**SINGLE + TWO STOREY EXTENSIONS AND INTERNAL ALTERATIONS  
WEST FARM COTTAGE, SIBFORD GOWER**

Further to my email correspondence with George Smith (Senior Planning Officer) between 1<sup>st</sup> - 23<sup>rd</sup> June 2021, we hereby enclose the following documents in PDF format in order to make a variation of condition application to planning permission 20/03601/F:

Client	Mr N. Mattinson	
Project	Alterations at West Farm Cottage, Sibford Gower	
Drawing	Proposed Site / Roof Plan	
Date	December '20	
Scale	1:100 @ A1	Drawn: RS
Job No	19-076	Drawing No: 101 C
architecture + interiors

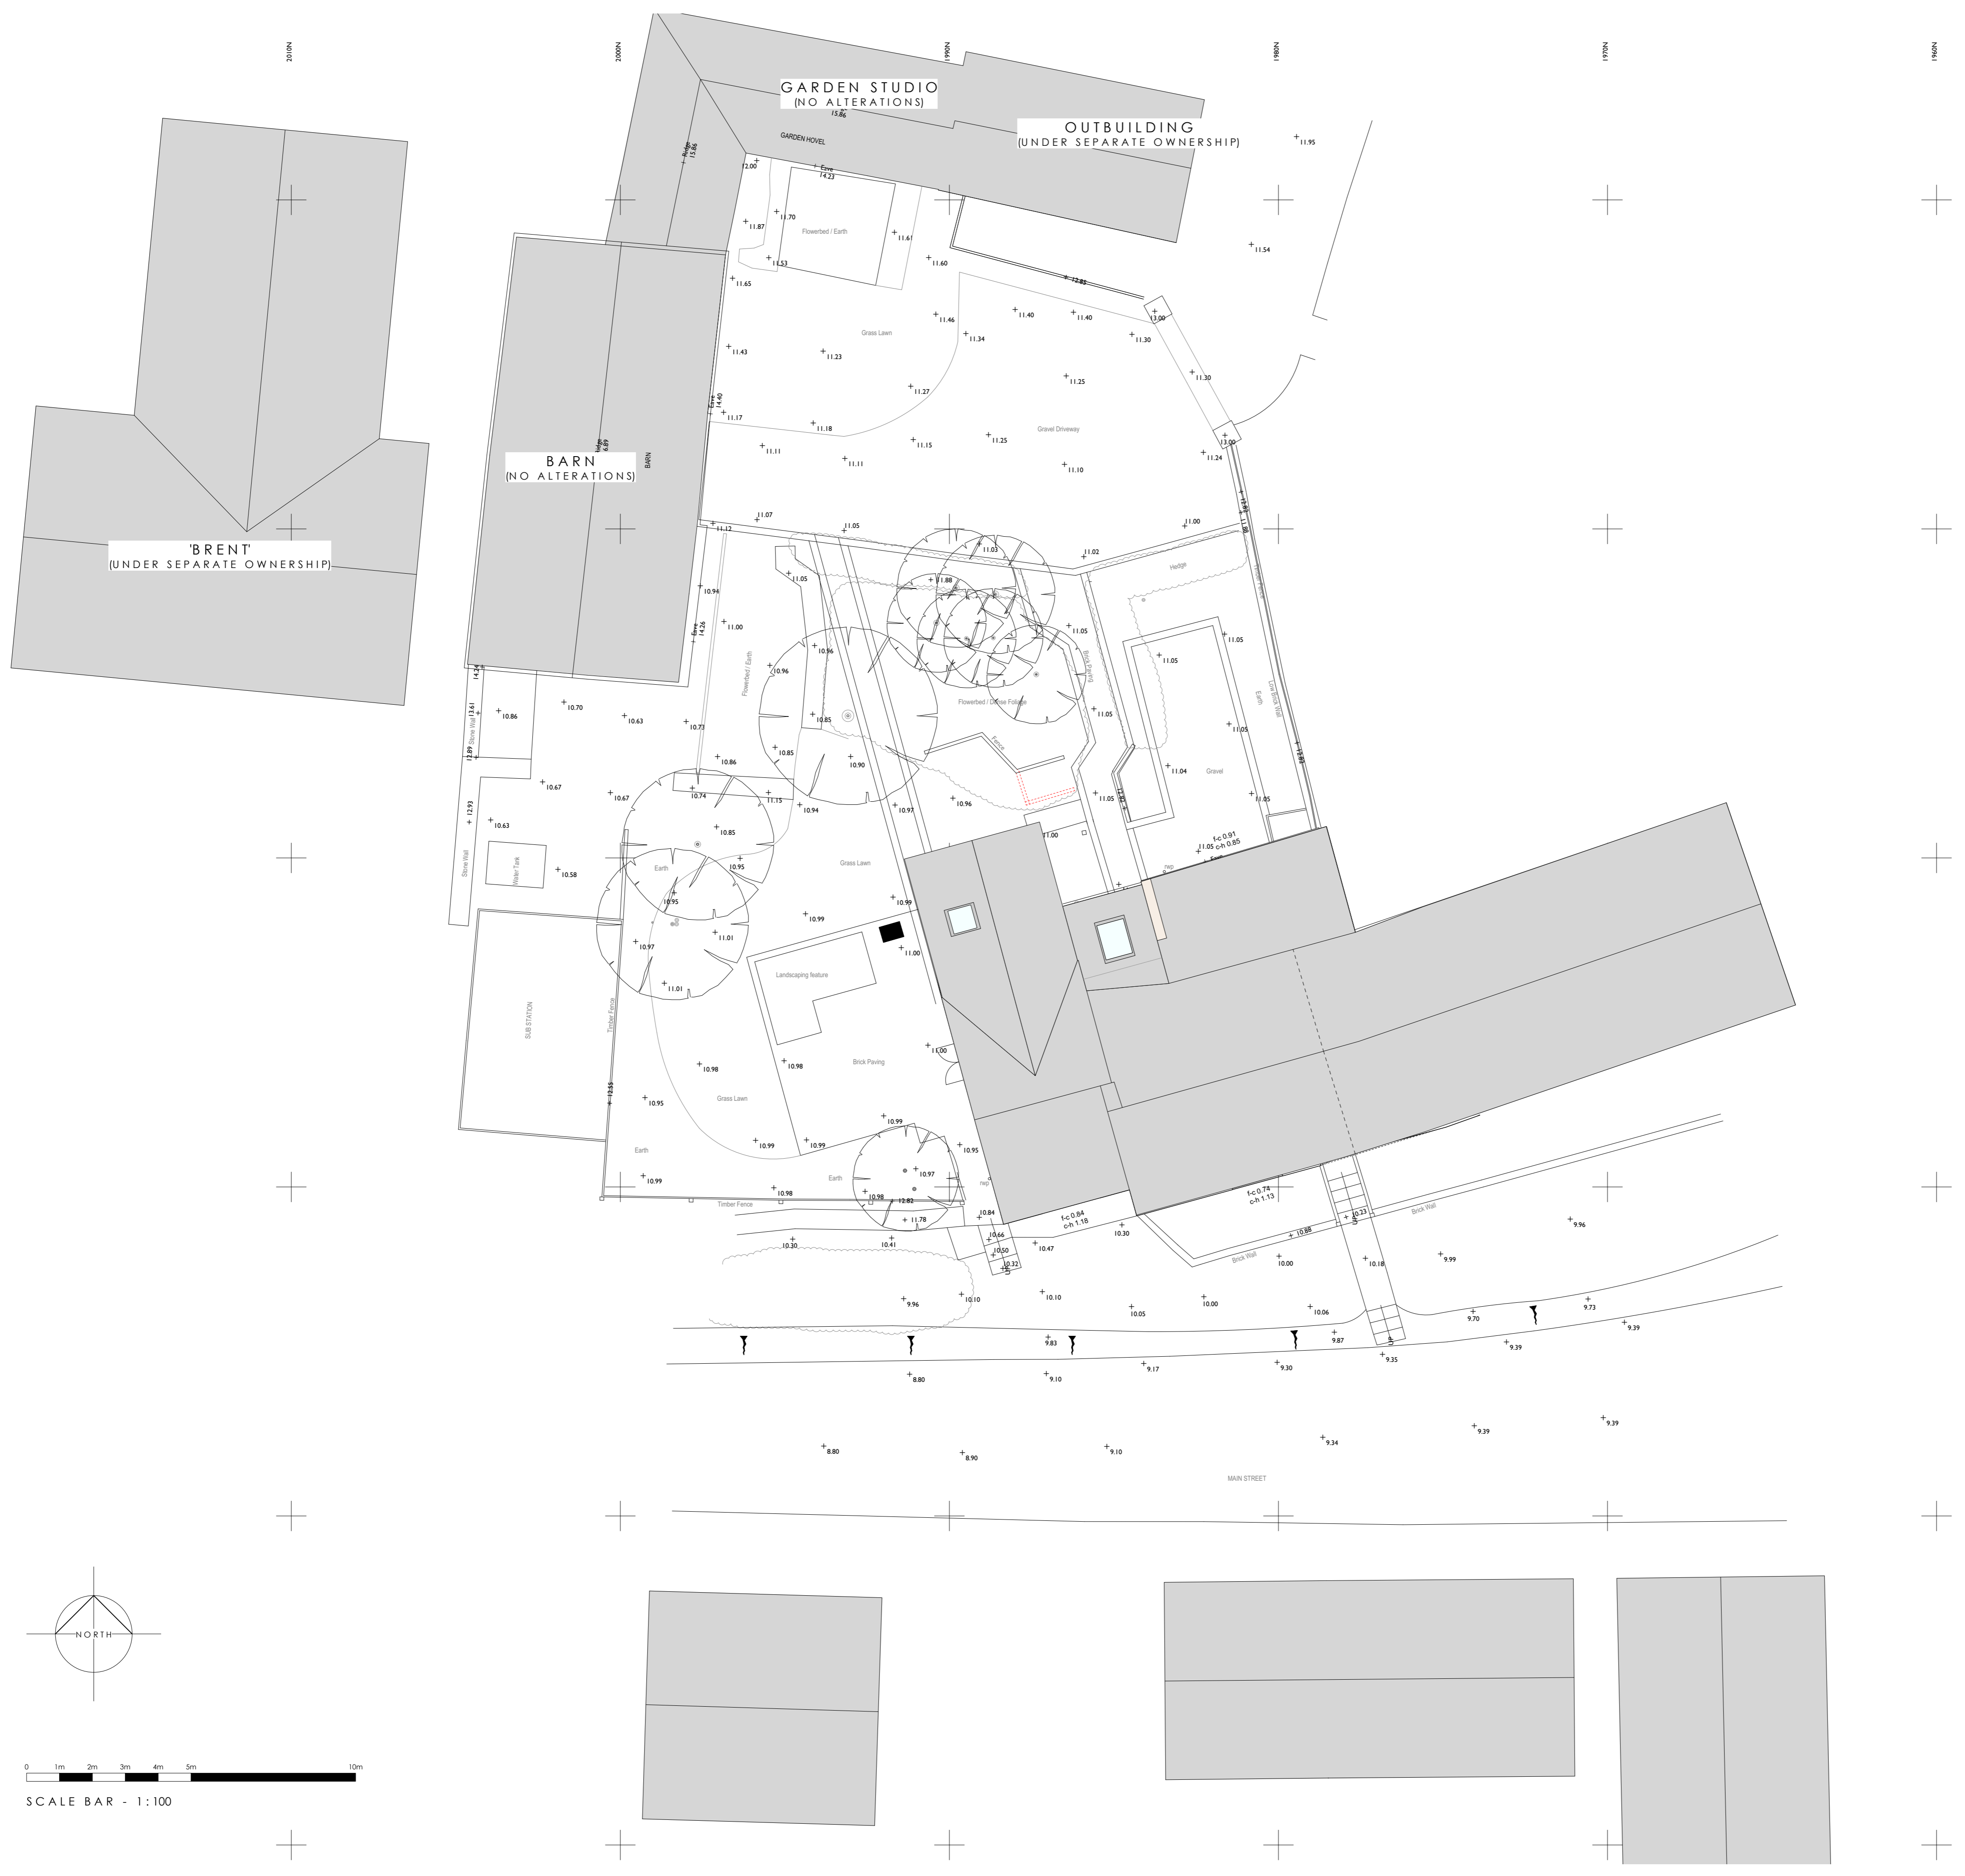
We wish to replace drawings 19\_076-100A with 19\_076-100B and 19\_076-101A with 19\_076-101C, to reflect the amendments to the approved two-storey extension, as discussed with George Smith.
